Re: M-51 Industrial Grading – *Technical Review 2*
PA 22002

After reviewing the revised application materials, for the above referenced proposal, the Planning Division has the following comments:

M-51 INDUSTRIAL, LLC
M-51 INDUSTRIAL
GRADING PLAN

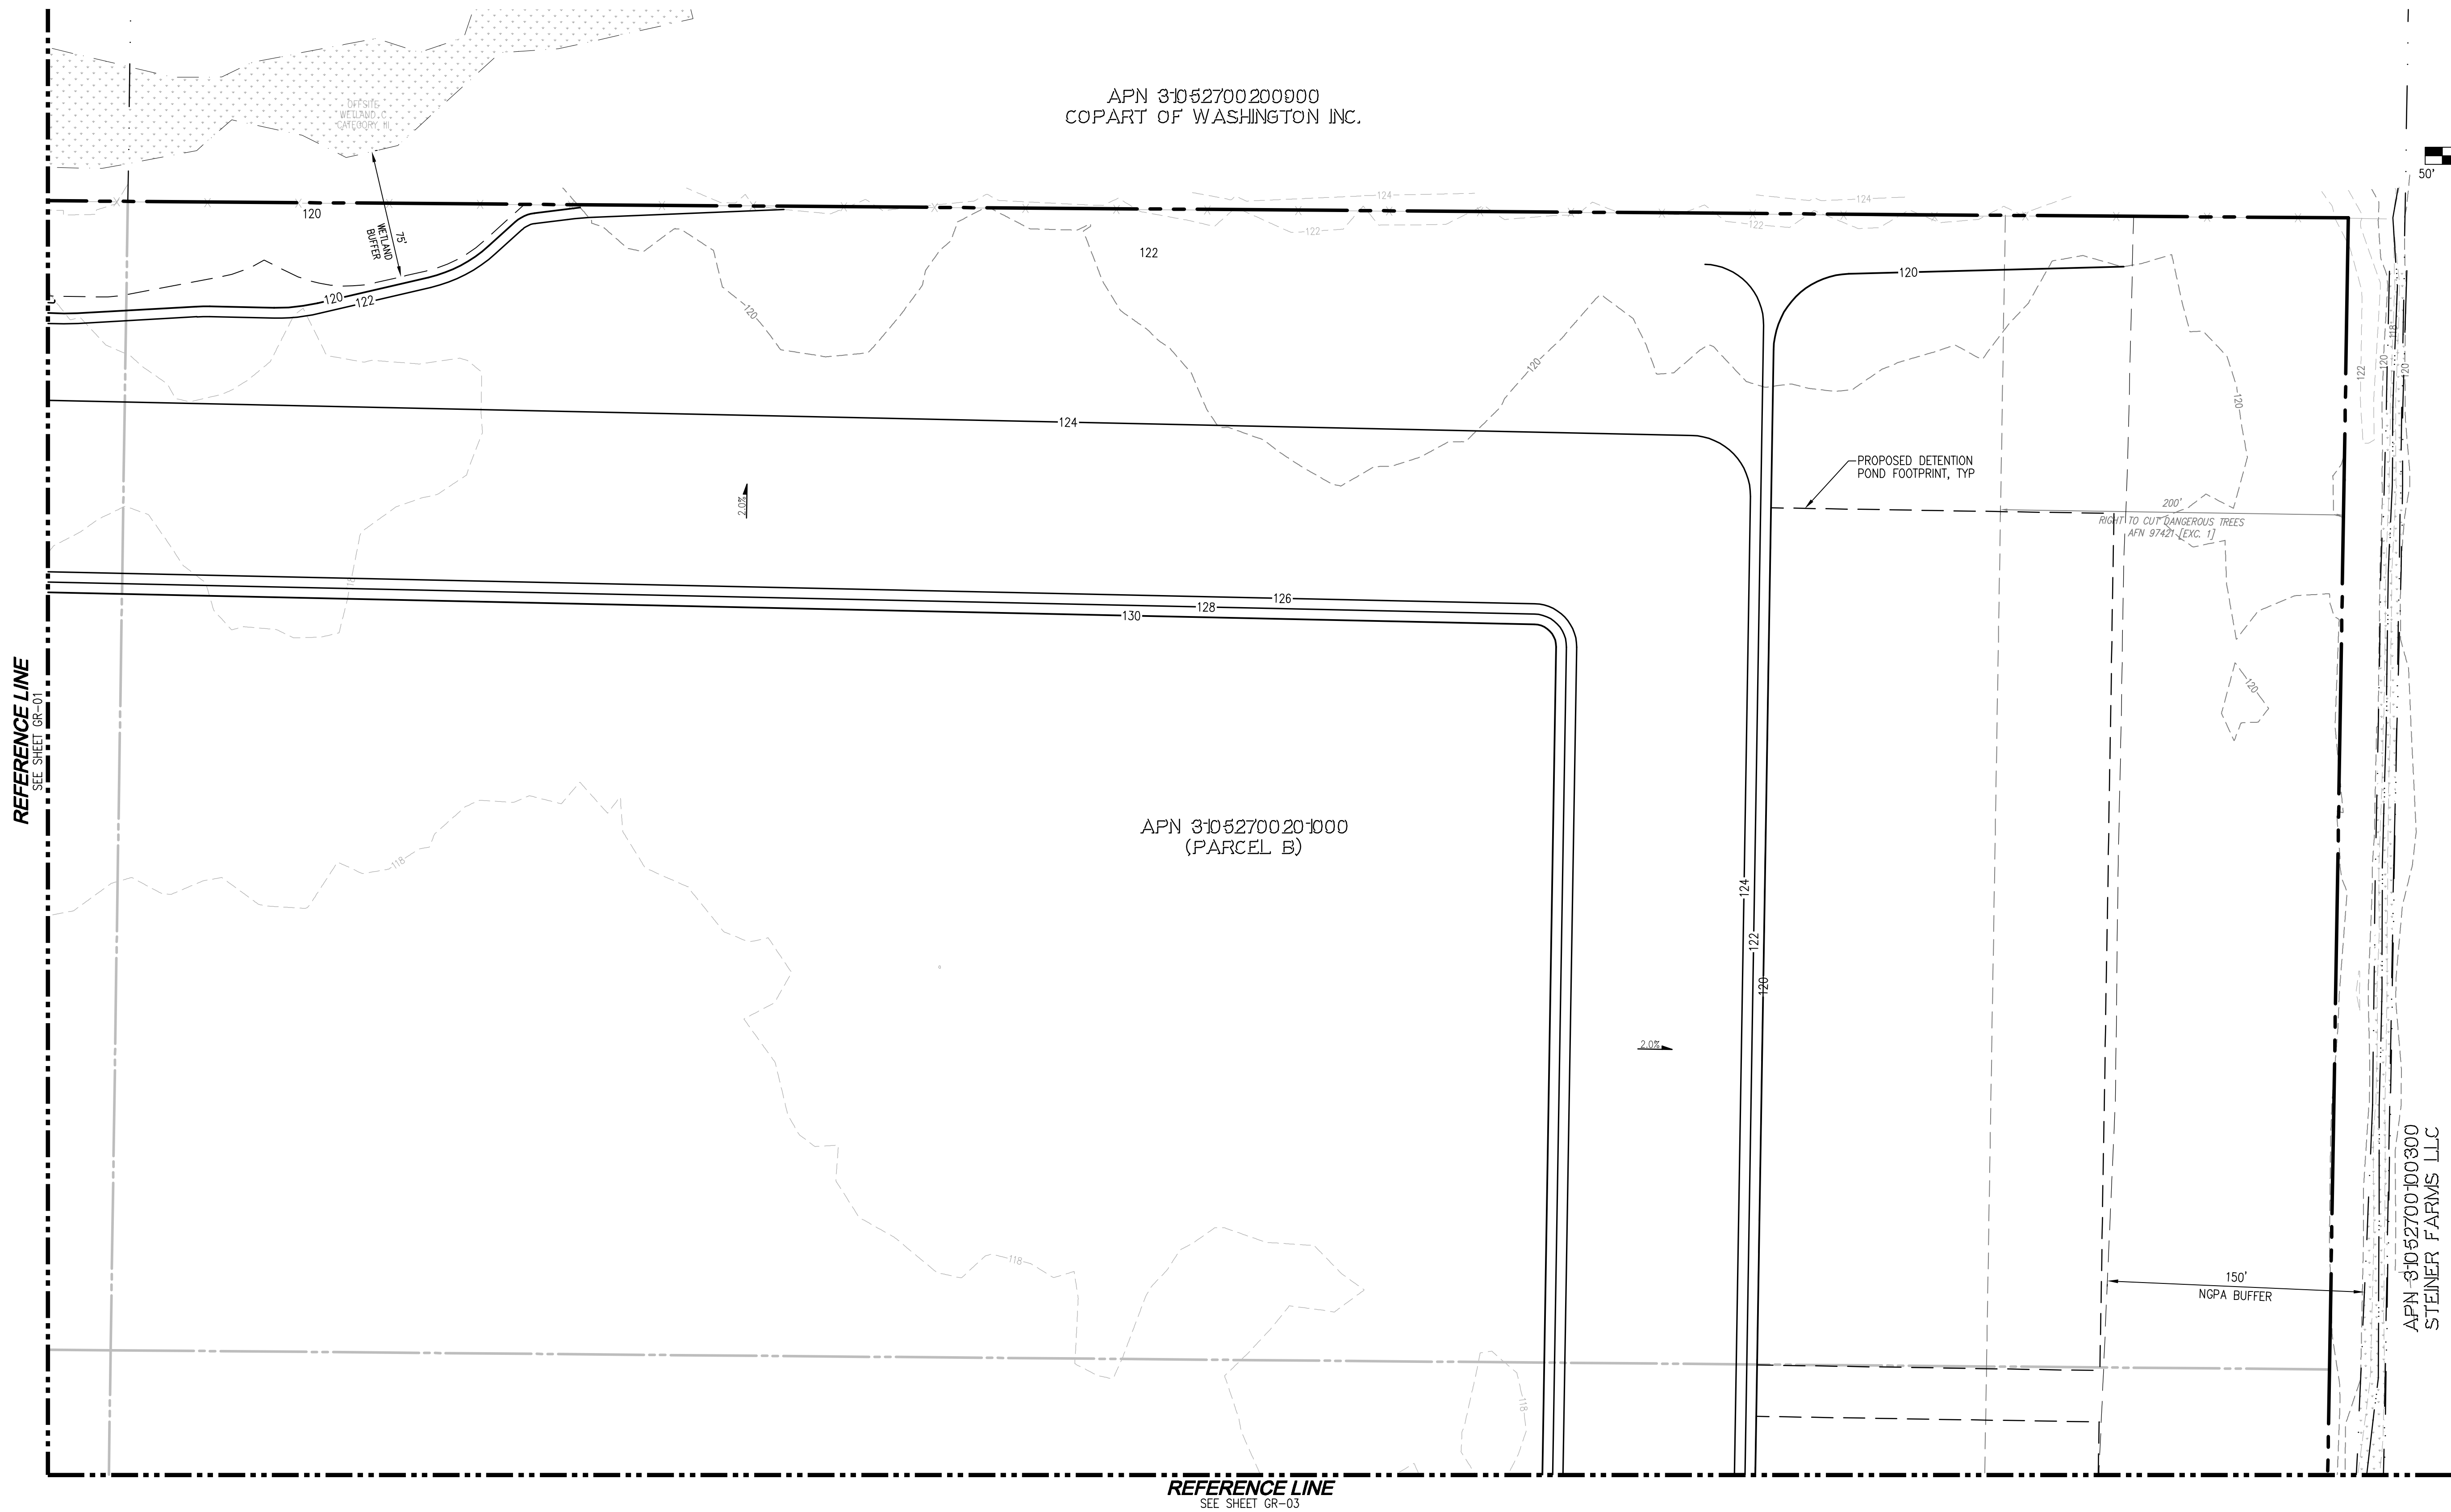
1. Sheet ER-01 & GR-01 shall be amended, as follows:
 - a. The plan shows installation of a temporary culvert and construction access onto 51st Avenue NE. Unless the applicant obtains approval from the Corp and DOE to impact the existing lineal ditch, which has been identified as a regulated critical area, the plans shall be revised and the temporary culvert and construction entrance shall be removed.

- b. It appears grading is proposed within the 75 foot Category III lineal ditch critical area buffer. The plans shall be required to be revised to move the silt fencing, clearing limits and grading activity a minimum of 75' from the edge of the lineal ditch critical area.

GR-03
SHEET 15 OF 16

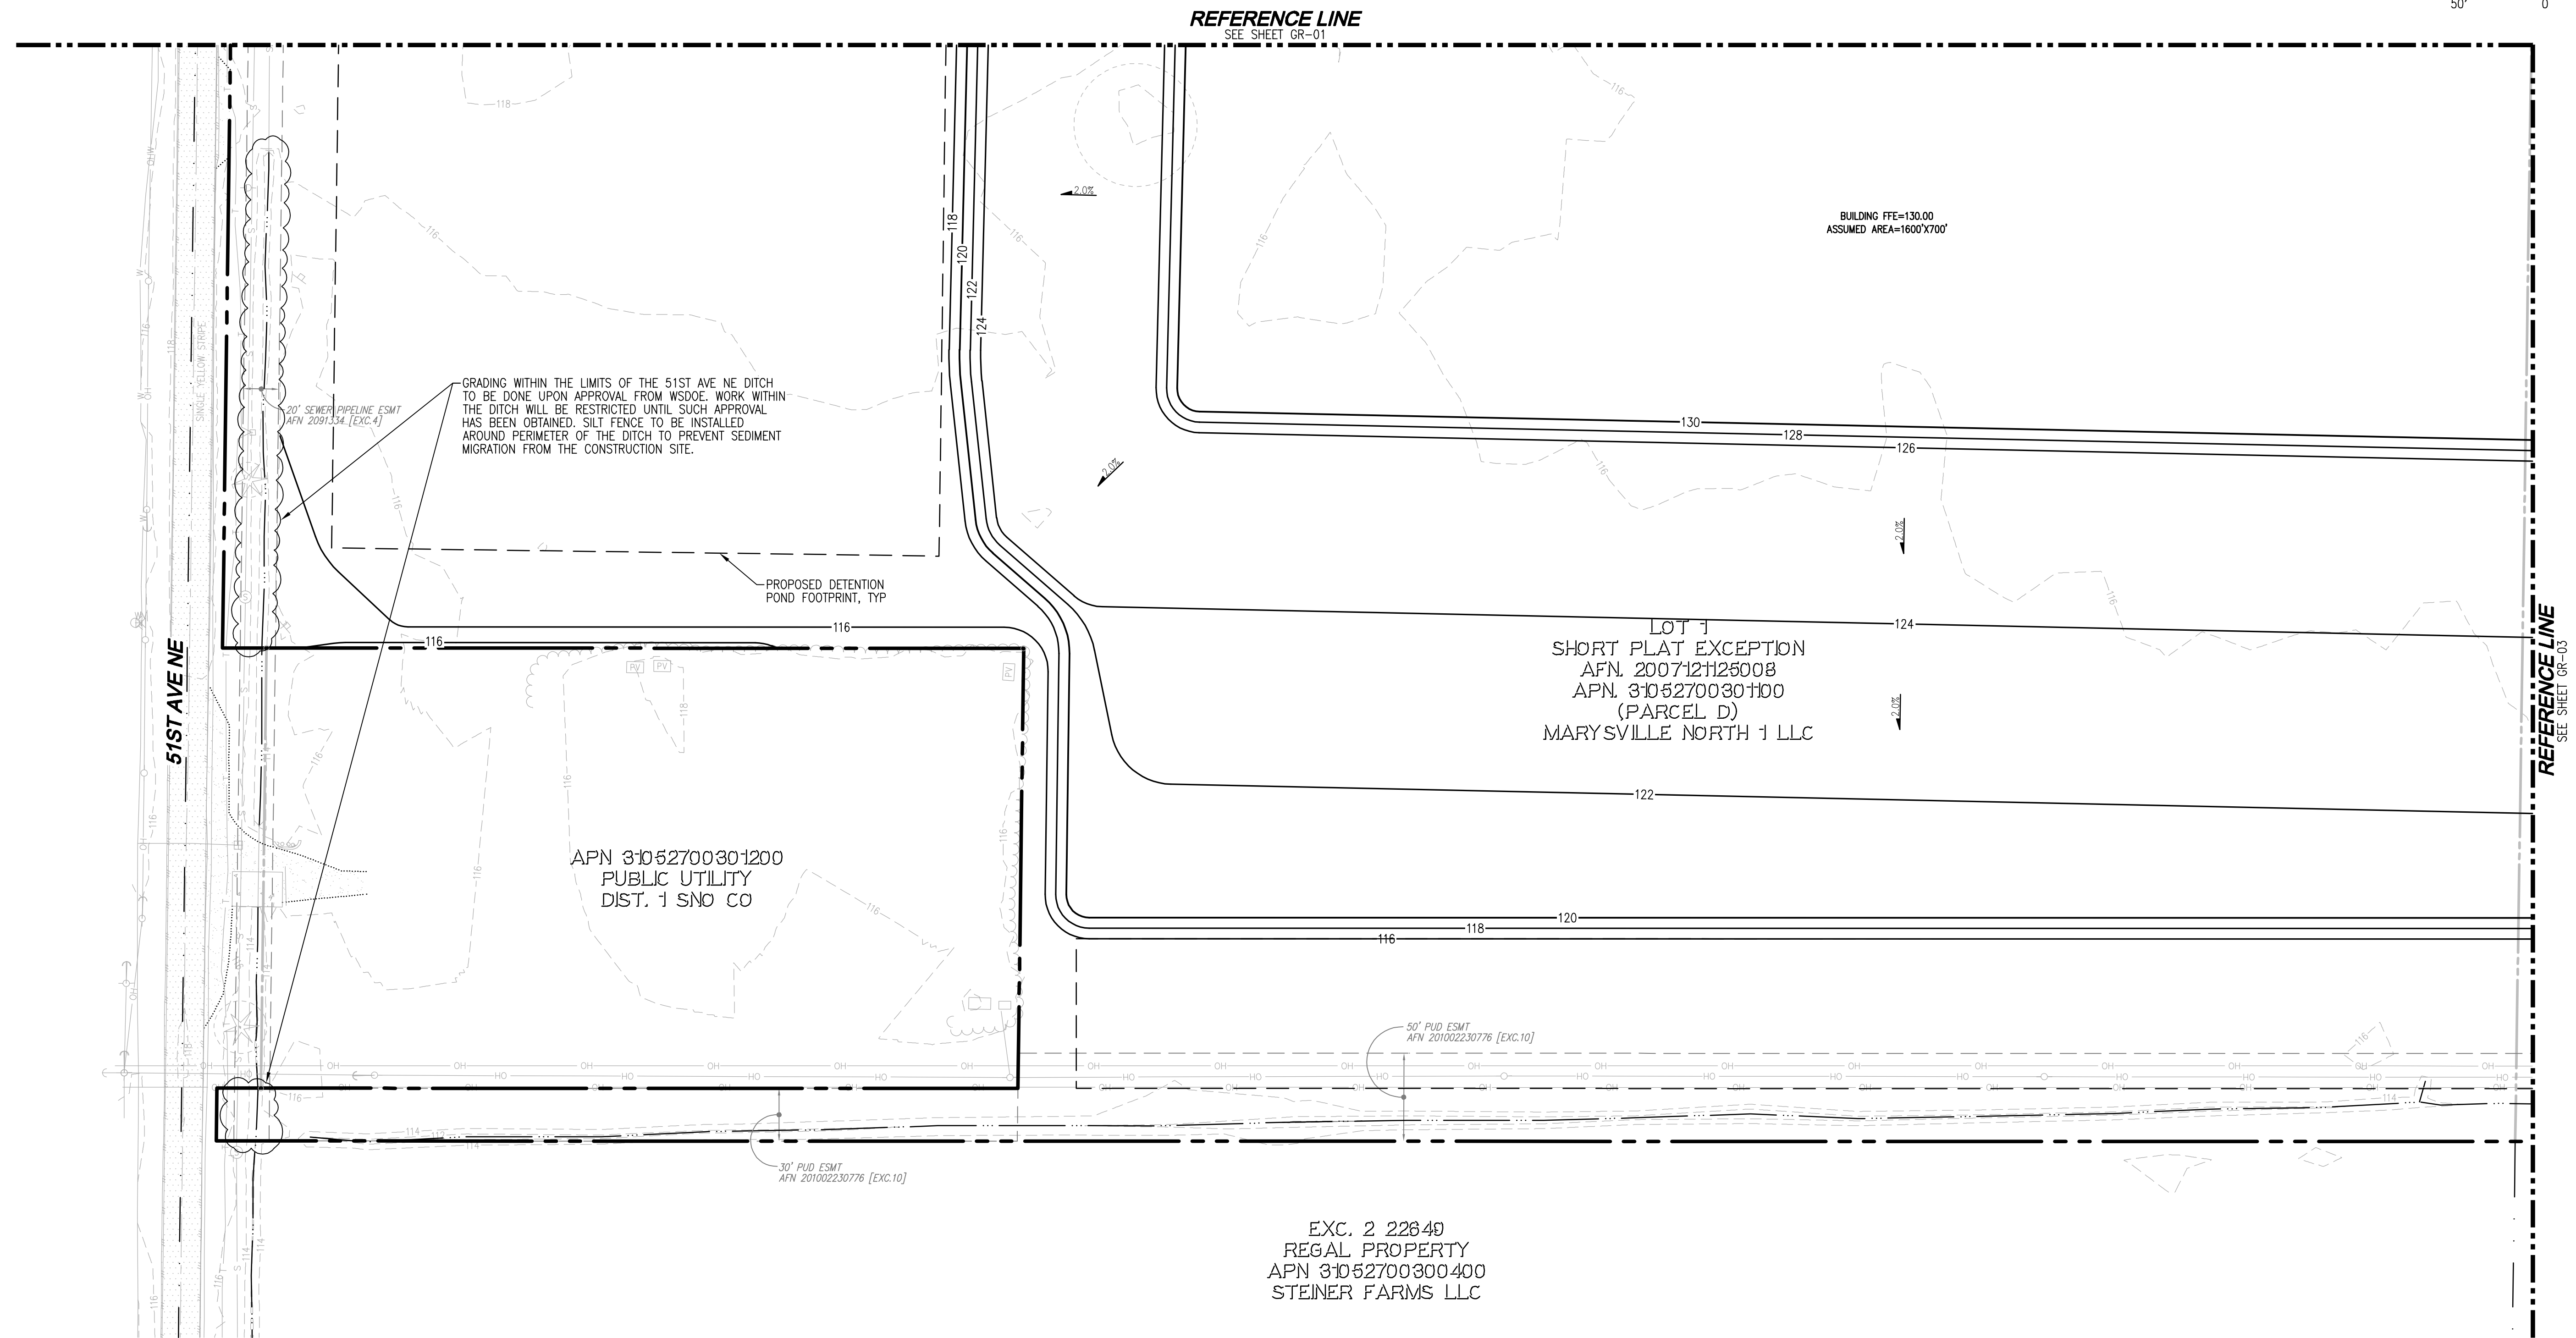
2. Sheet ER-04 & GR-04 shall be amended, as follows:
 - a. It appears grading is proposed within the 75 foot Category III lineal ditch critical area buffer. The plans shall be required to be revised to move the silt fencing, clearing limits and grading activity a minimum of 75 feet from the edge of the lineal ditch critical area.

- b. The existing site entrance can remain, as proposed, however, clearly define the silt fencing and clearing limits south and north of the existing site entrance, located outside of the required 75 foot lineal ditch critical area buffer.
